Recommendation Report for Planning Permission**REF NO:** AB/60/17/PL**LOCATION:** Land rear of 74 & 76 Canada Road
Arundel**PROPOSAL:** 1 No. dwelling with carport & associated off street parking (resubmission following AB/130/16/PL).**SITE AND SURROUNDINGS**

Drawing No.	100 A	Revision
-------------	-------	----------

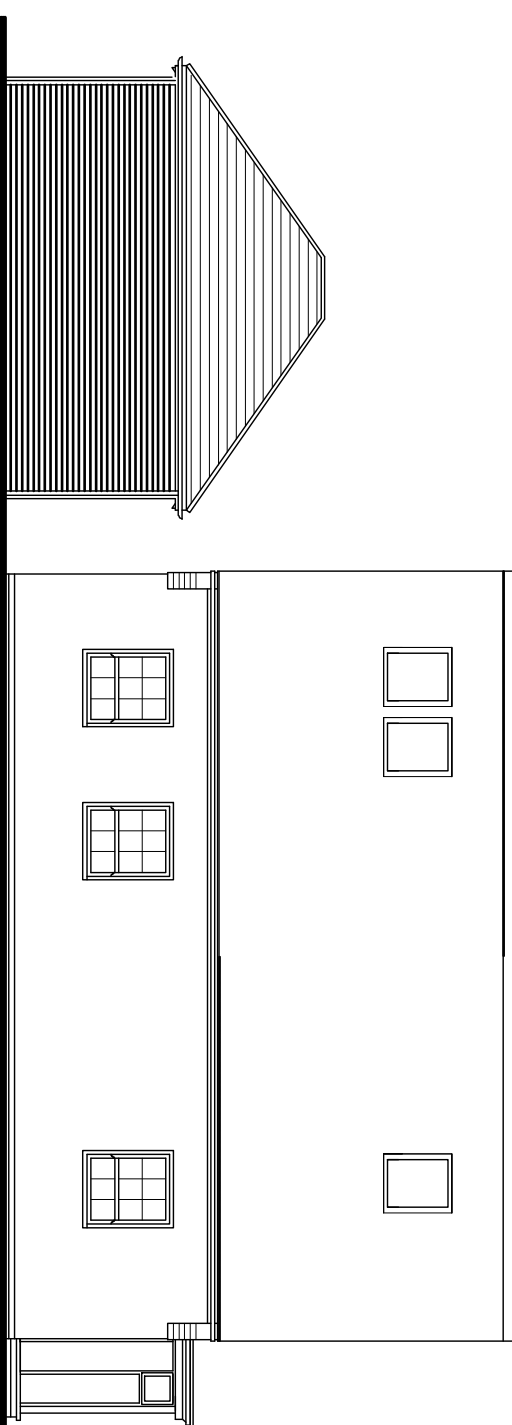
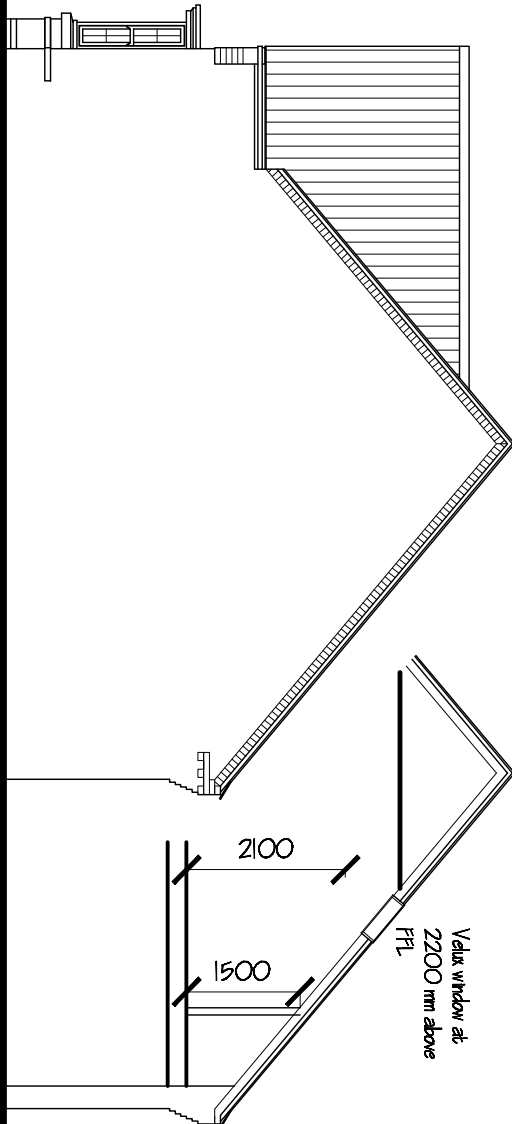
One Objection - The proposed development is a 4 bedroom bungalow, set over two storeys, and not 3 bedrooms.

Privacy - The building of this two storey property will seriously impact on privacy of neighbouring family. The rear of the proposed building will be just 6 metres from our boundary. We objected previously when it was 10 metres. This has been further reduced. Although a bungalow it will be over two storeys, the height of the proposed building will completely over look our garden and into the rear of our home. A fundamental human right is the right to a private life. The erection of this dwelling will impede this right. Parking - The area is blighted by parking problems. From the plans a new crossover the width of at least four garages has been implemented thus losing a significant amount of existing on street parking. Currently the on street parking is available for all residents. However the crossover point will be removing these spaces and reserving parking for those who are involved in this project. This will have a detrimental impact on a number of residents locally. I see that there are also two individual garages and drives for no. 76 and 74. These add to the loss of on street parking. The existing double garage at 76 is not currently used for parking. In the plans it is said there are no current parking

The concerns of the neighbour in relation to overlooking impacts are not agreed. A distance of 6m is considered sufficient to preclude any materially adverse overbearing impacts and the roof lights in the rear elevation are high enough to preclude adverse overlooking effects and a material loss of privacy.

Drawing No.	Revision
101 A

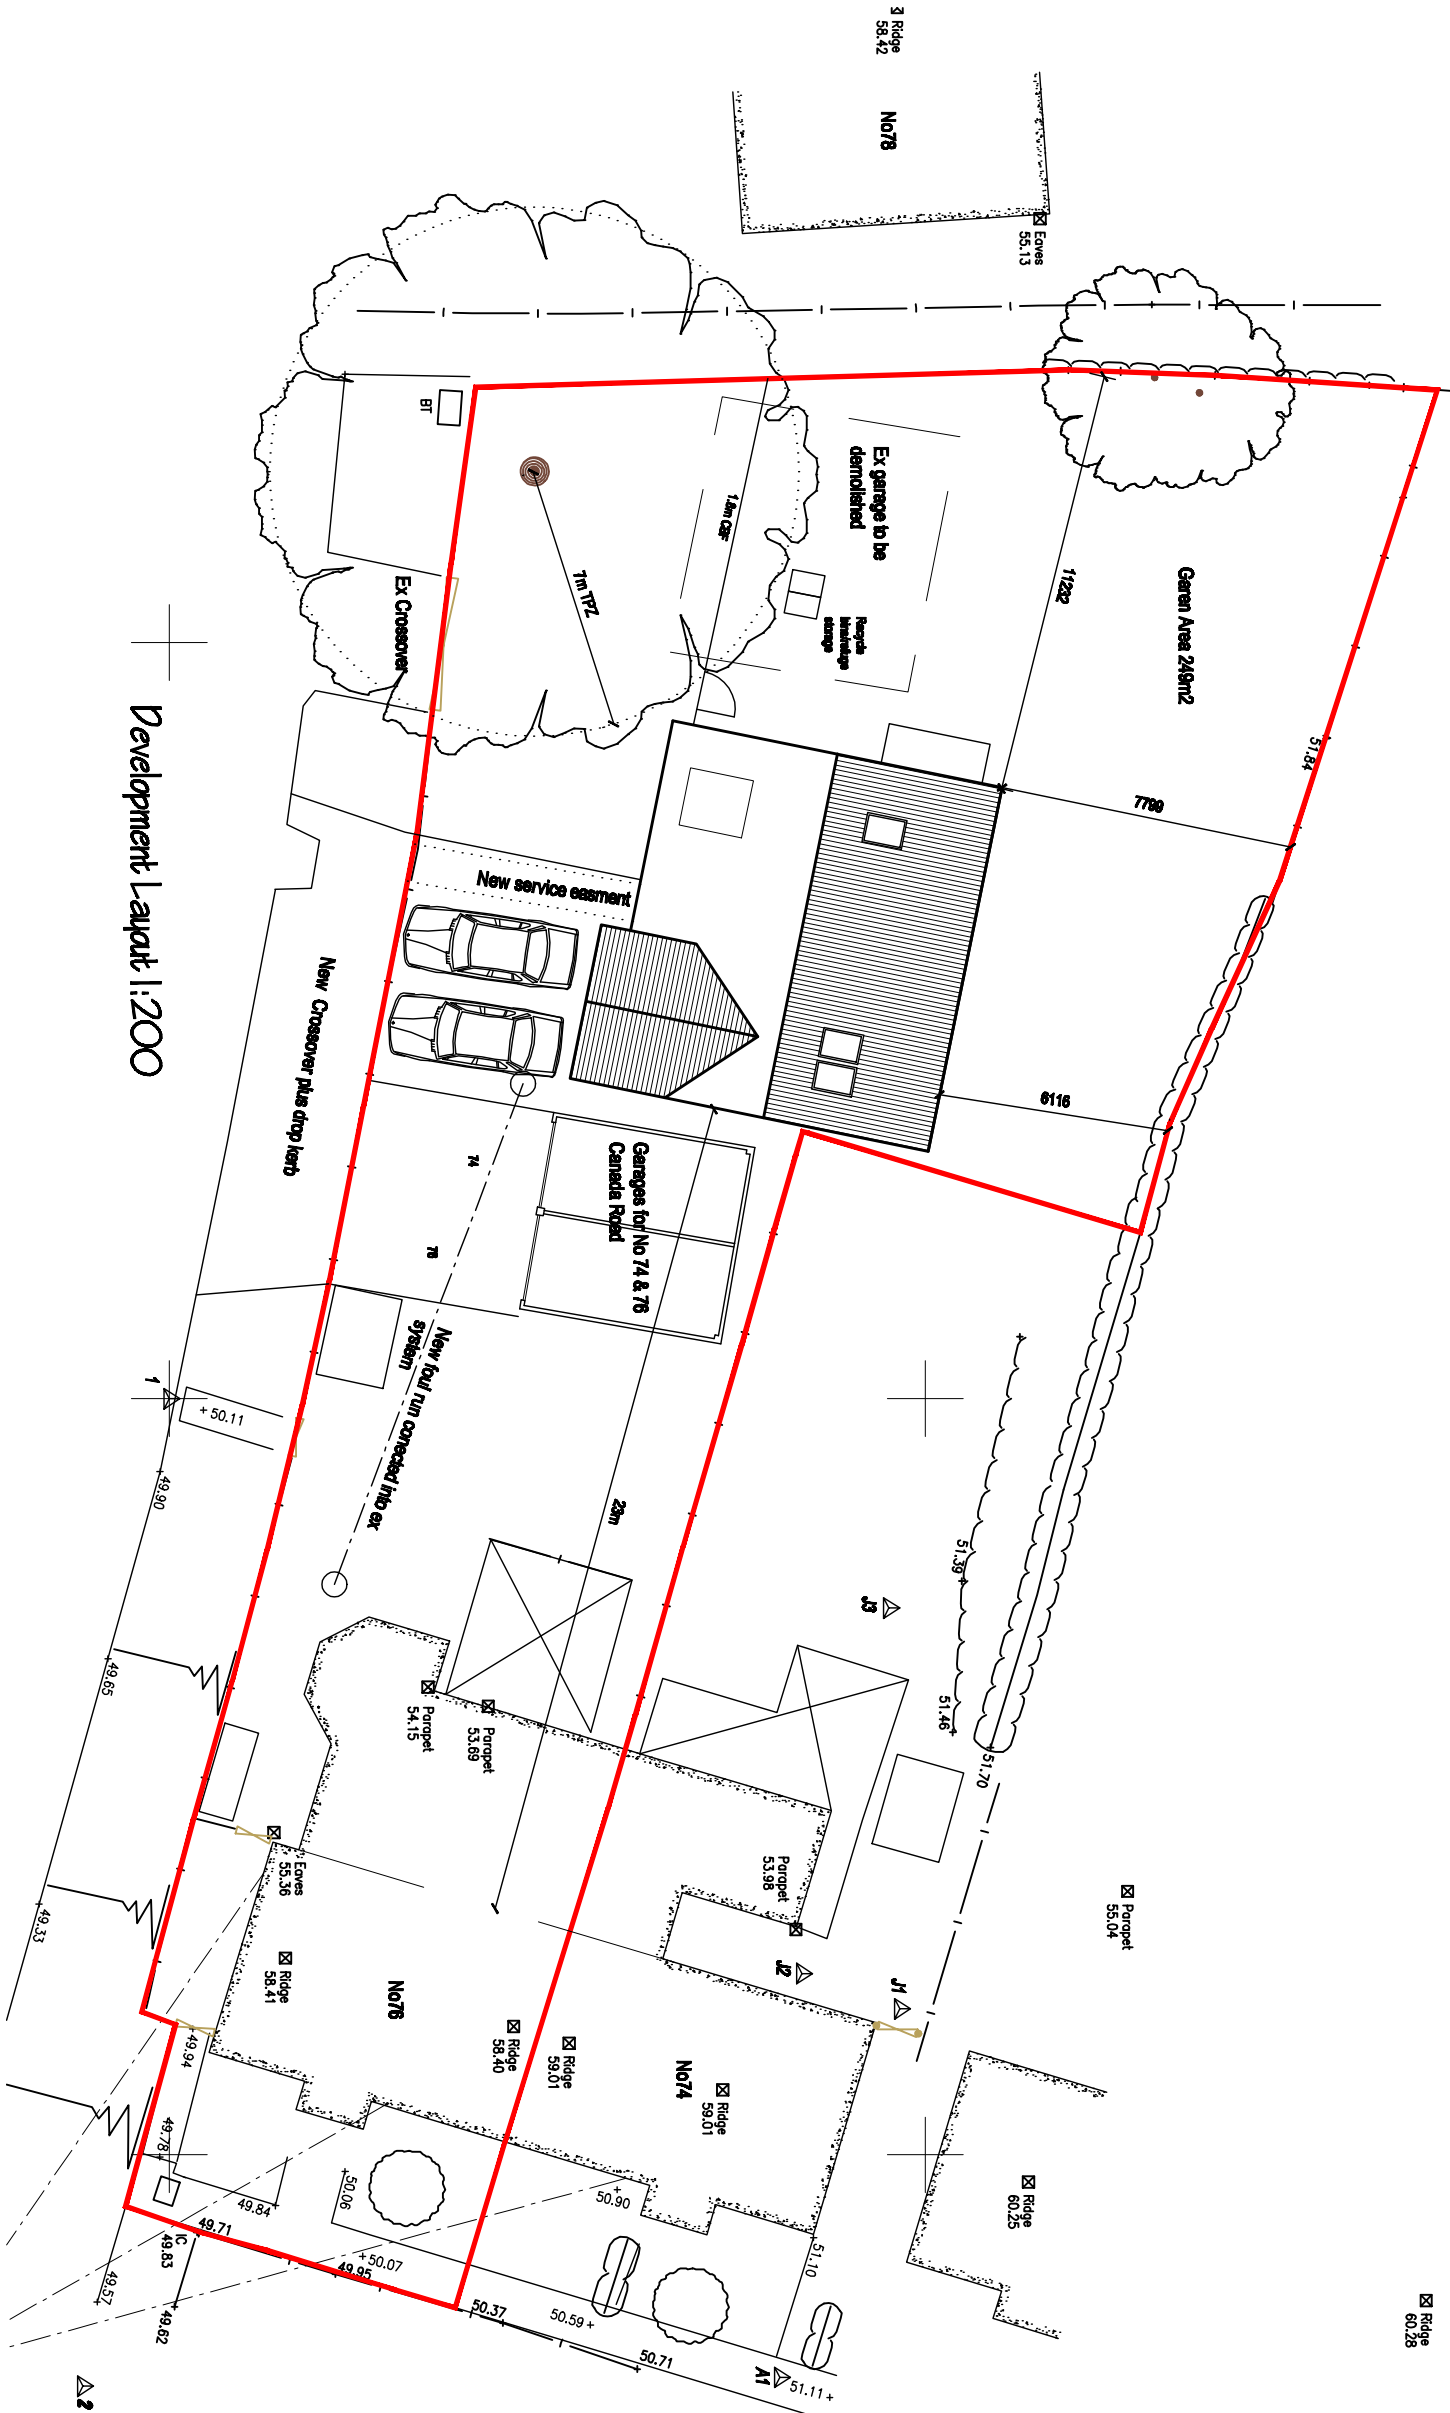
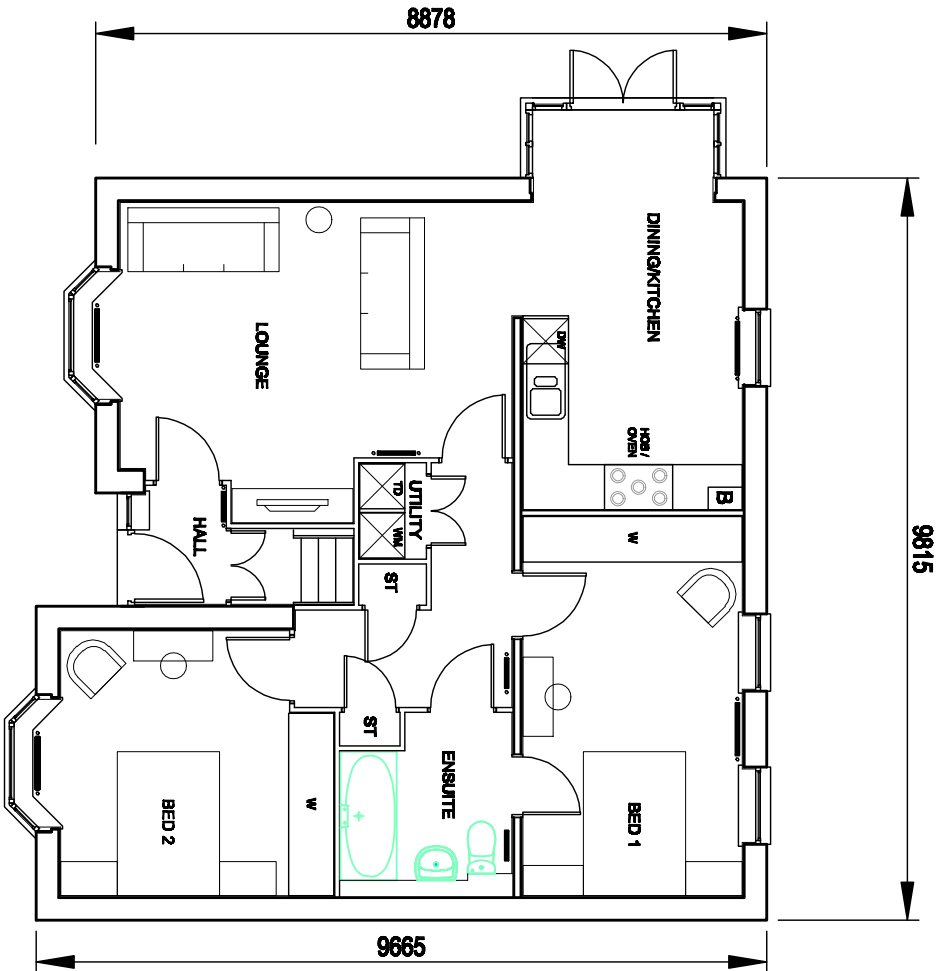
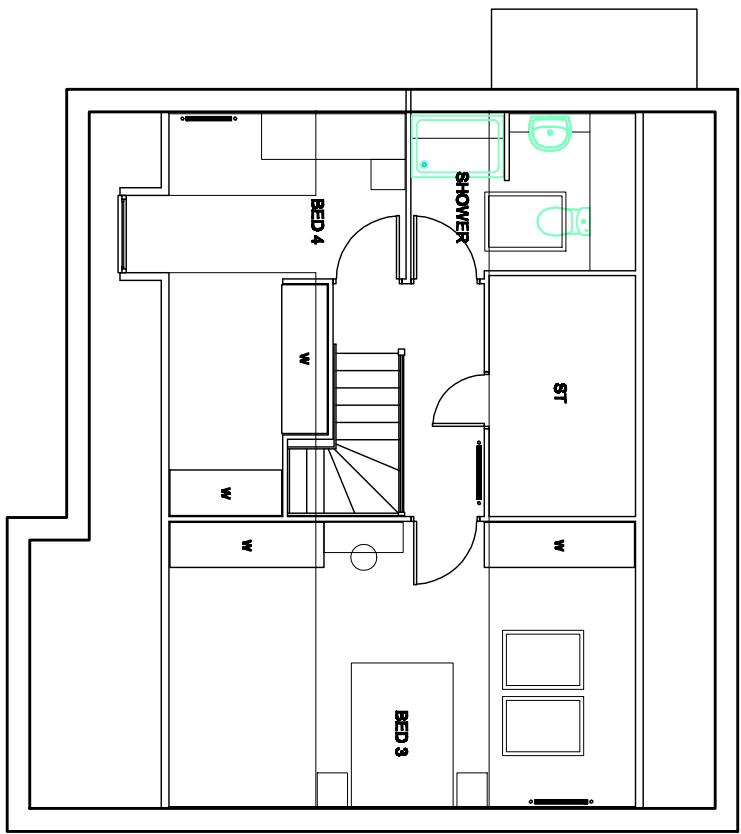
provisions and this project will create 4 spaces. However any perceived gain is off set by the loss of on street parking spaces to allow access to the proposed development. This is simply monopolizing already limited parking.

A study of the block plan demonstrates that off street parking to serve the new dwelling will be provided for 2 vehicles. This is in accordance with the WSCC Parking Demand Calculator. The LHA would prefer that a turn on site is provided to enable vehicles to exit onto the highway in a forward gear, however, there does not appear to be sufficient space to achieve this. The drive is to be constructed using tarmac; this is in accordance with WSCC guidance which advises against the use of gravel/shingle to prevent overspill onto the public highway.

An inspection of the plans establishes that the dimensions for the new double car port to serve nos. 74 & 76 meet with WSCC guidance.

The traffic issues are largely as previously approved and have not been objected to by County Highways and a refusal in relation to traffic generation and loss of parking could not be substantiated.
